TfNSW Reference: SYD21/00462/07

Departments Reference: SSD-17647189

**EXHIBITION OF EIS – ACCESS LOGISTICS PARK - 884-928 - MAMRE ROAD -
KEMPS CREEK**

Attachment A

info@asongroup.com.au

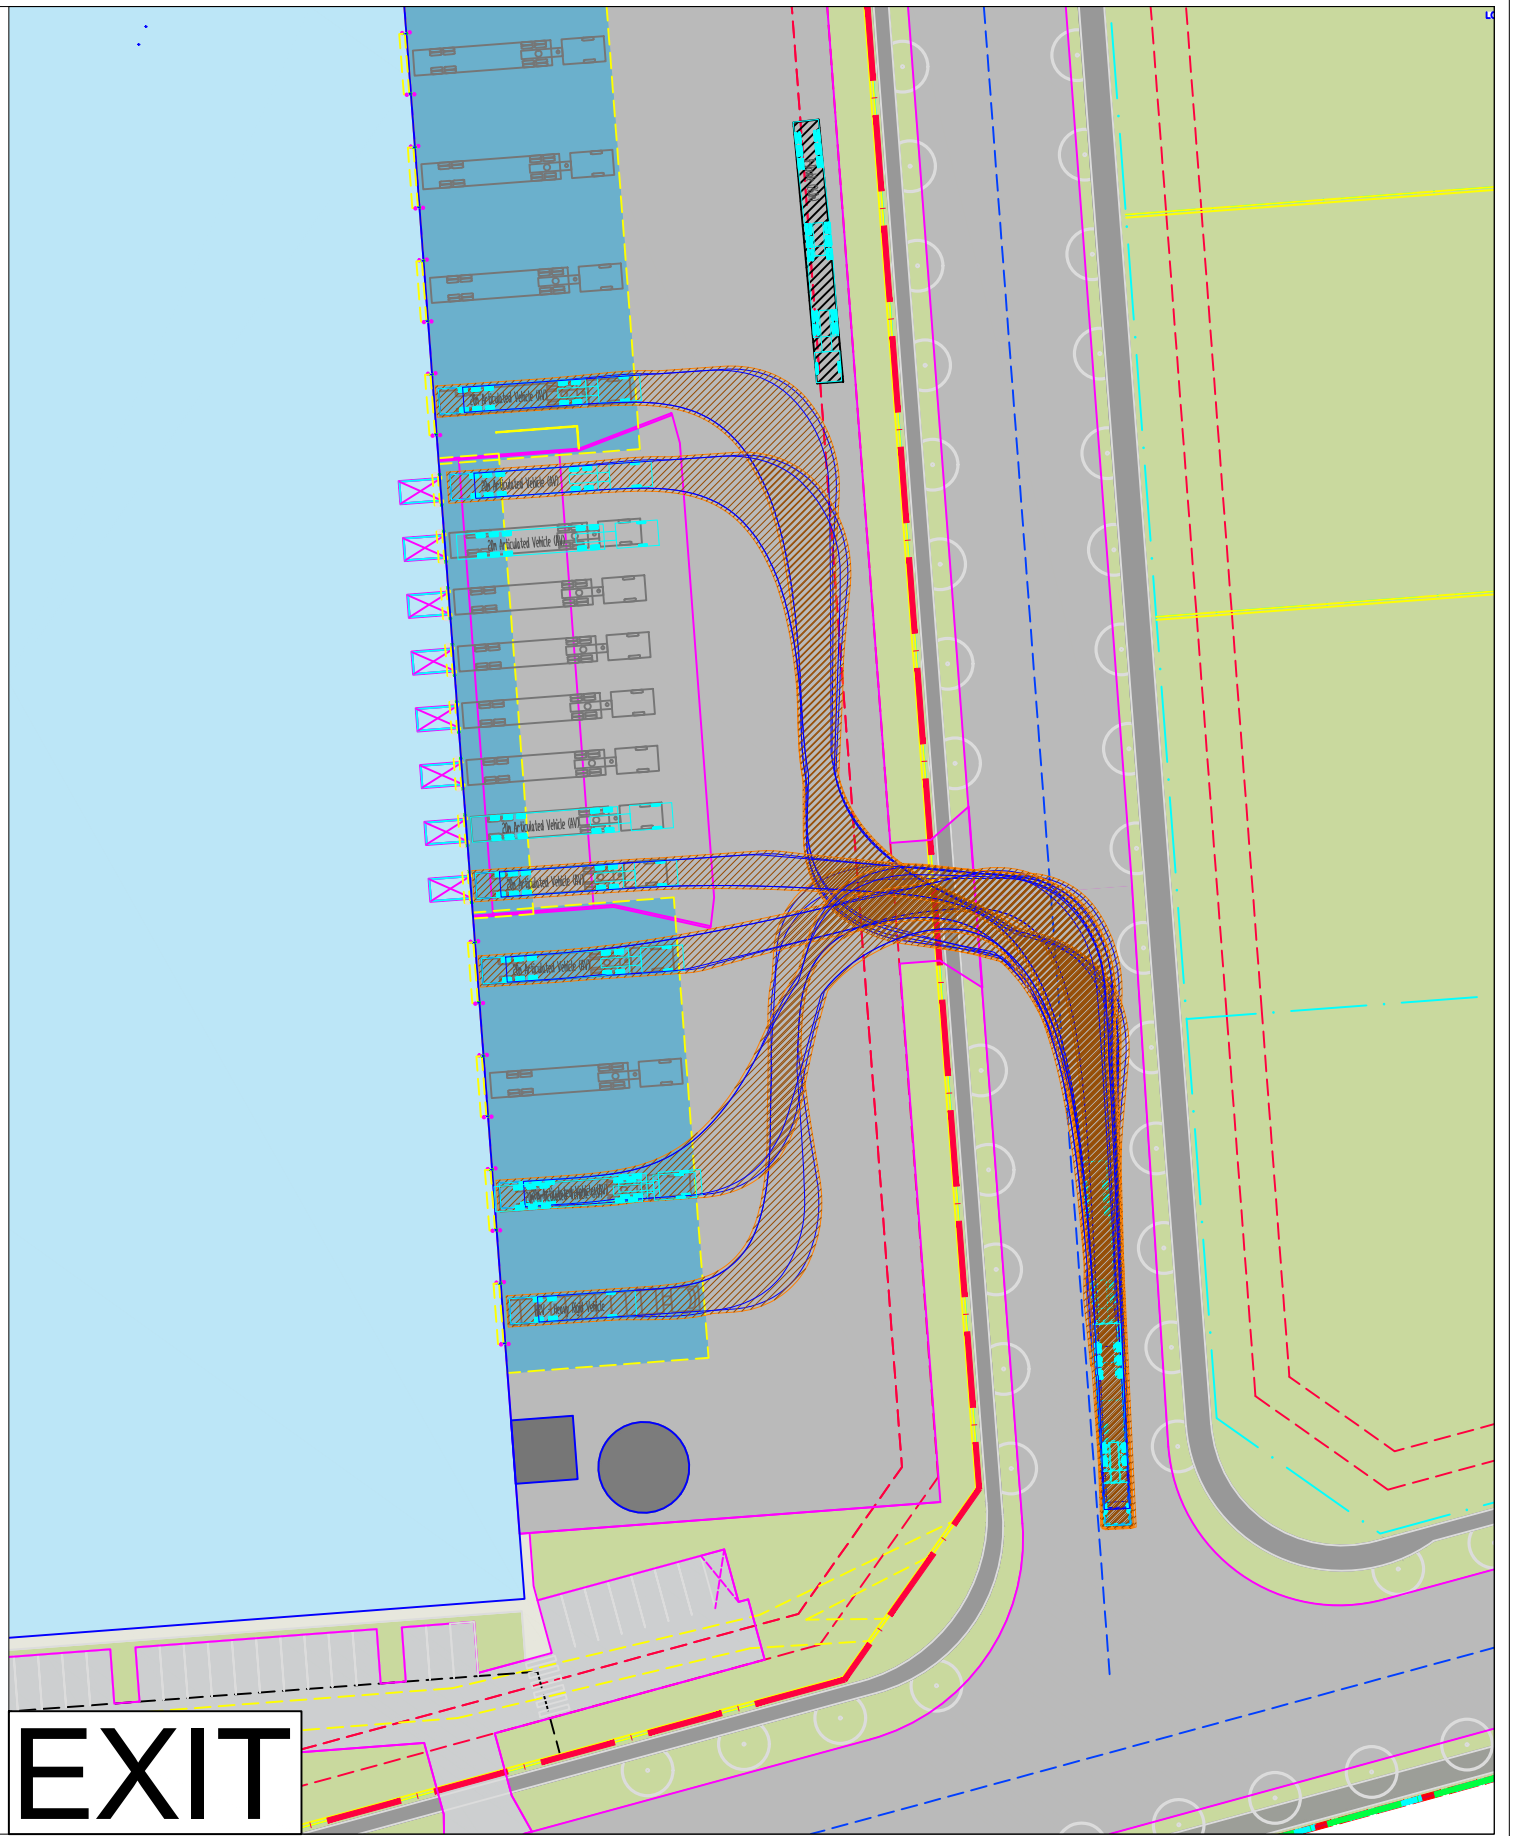
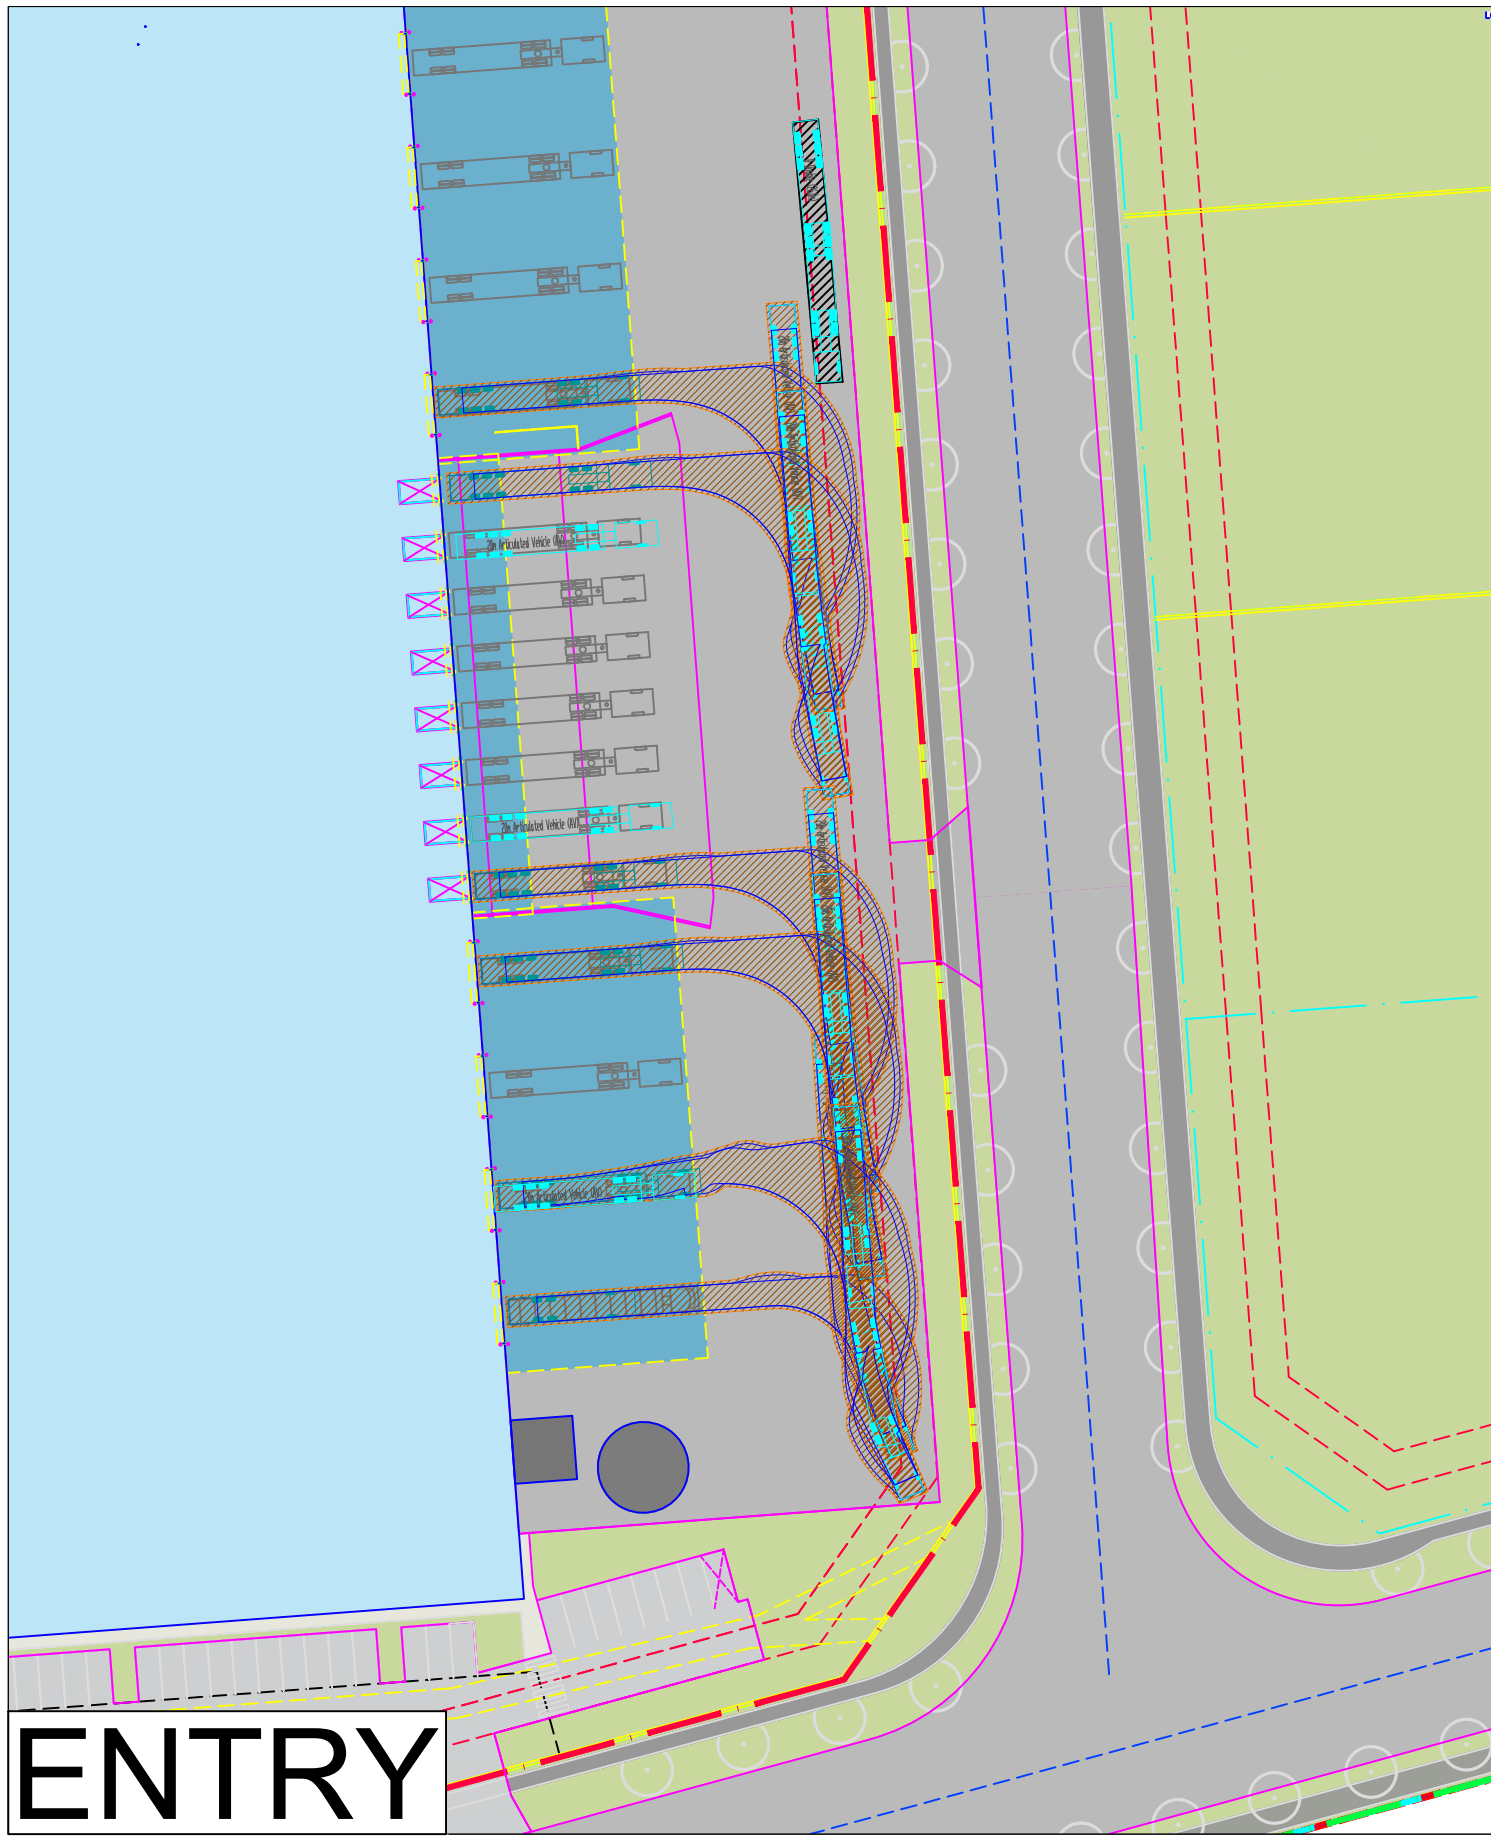
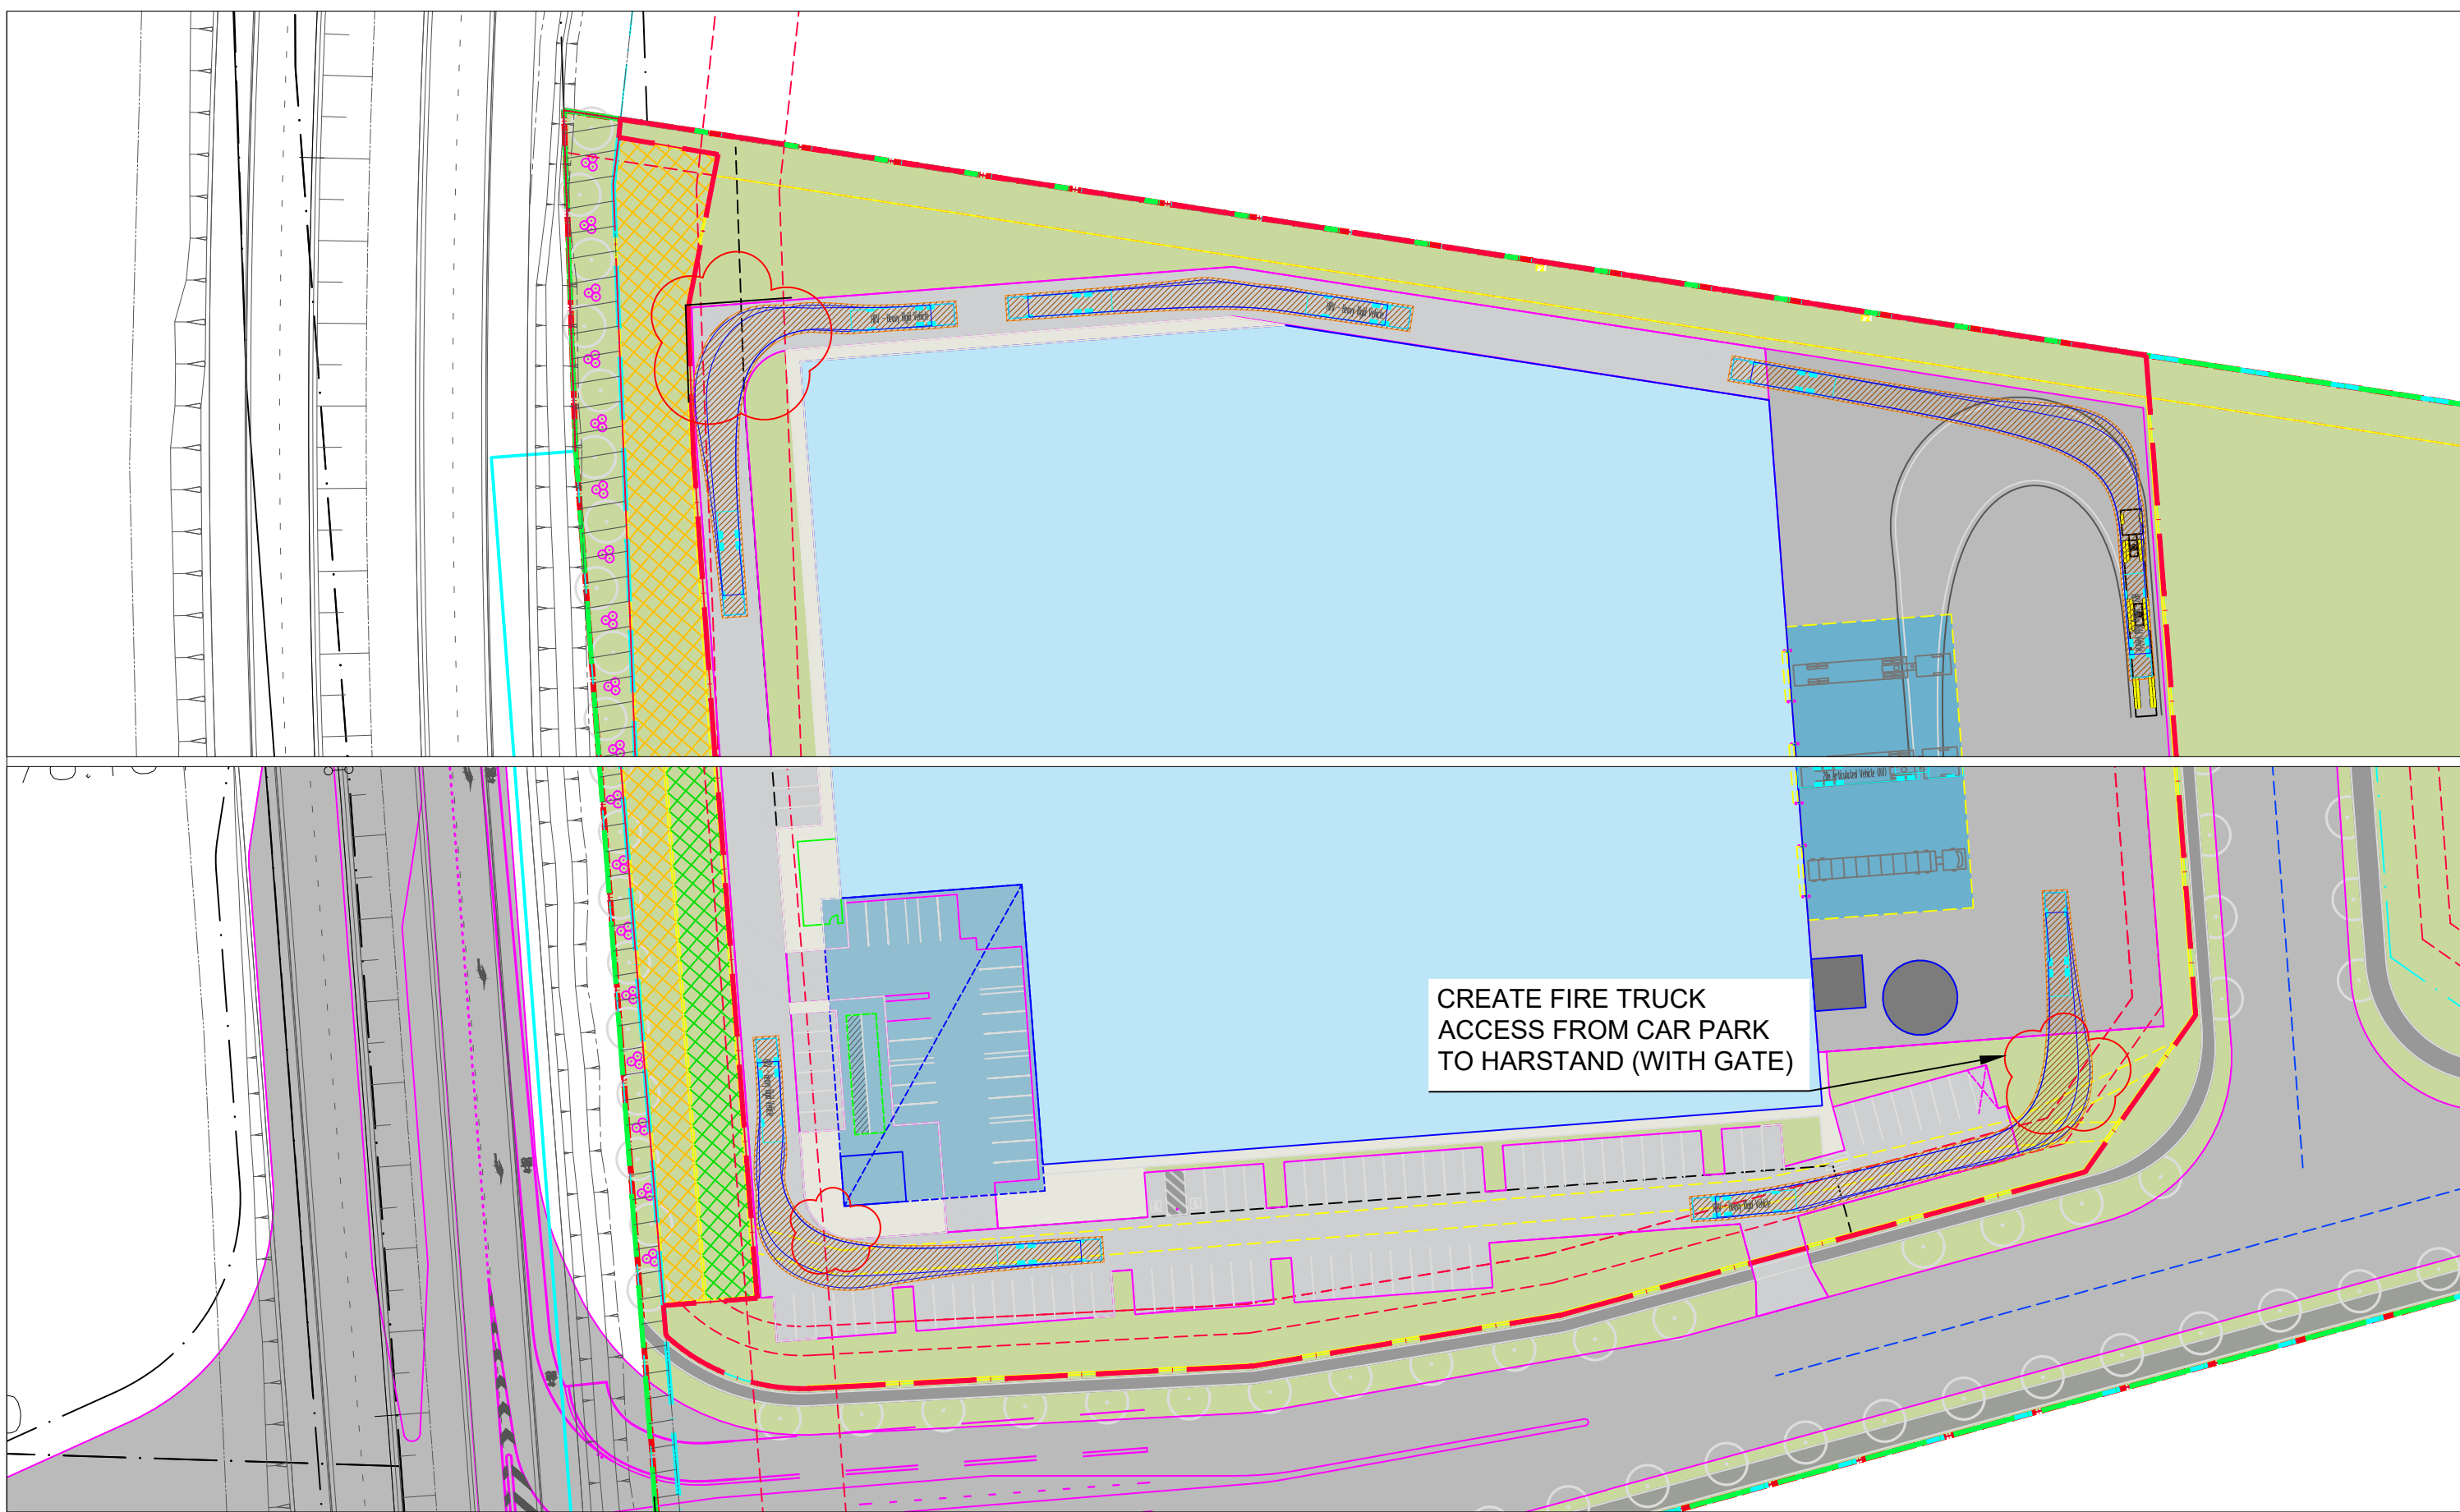
Appendix B. Design Advice & Swept Paths

- a. Swept Paths analysis is missing the test vehicle of 36m long B triple (PBS Level 3 Type A) as per the Mamre Rd Precinct Draft DCP.
- b. Figure 5 shows swept path diagrams for the proposed roundabout south-east corner of the site. No swept path appears to be provided for a vehicle travelling from west to east through the roundabout which would appear to be the tightest manoeuvre for a longer vehicle.

It is requested swept path diagrams be provided demonstrating the design vehicle is able to adequately manoeuvre through these intersections.
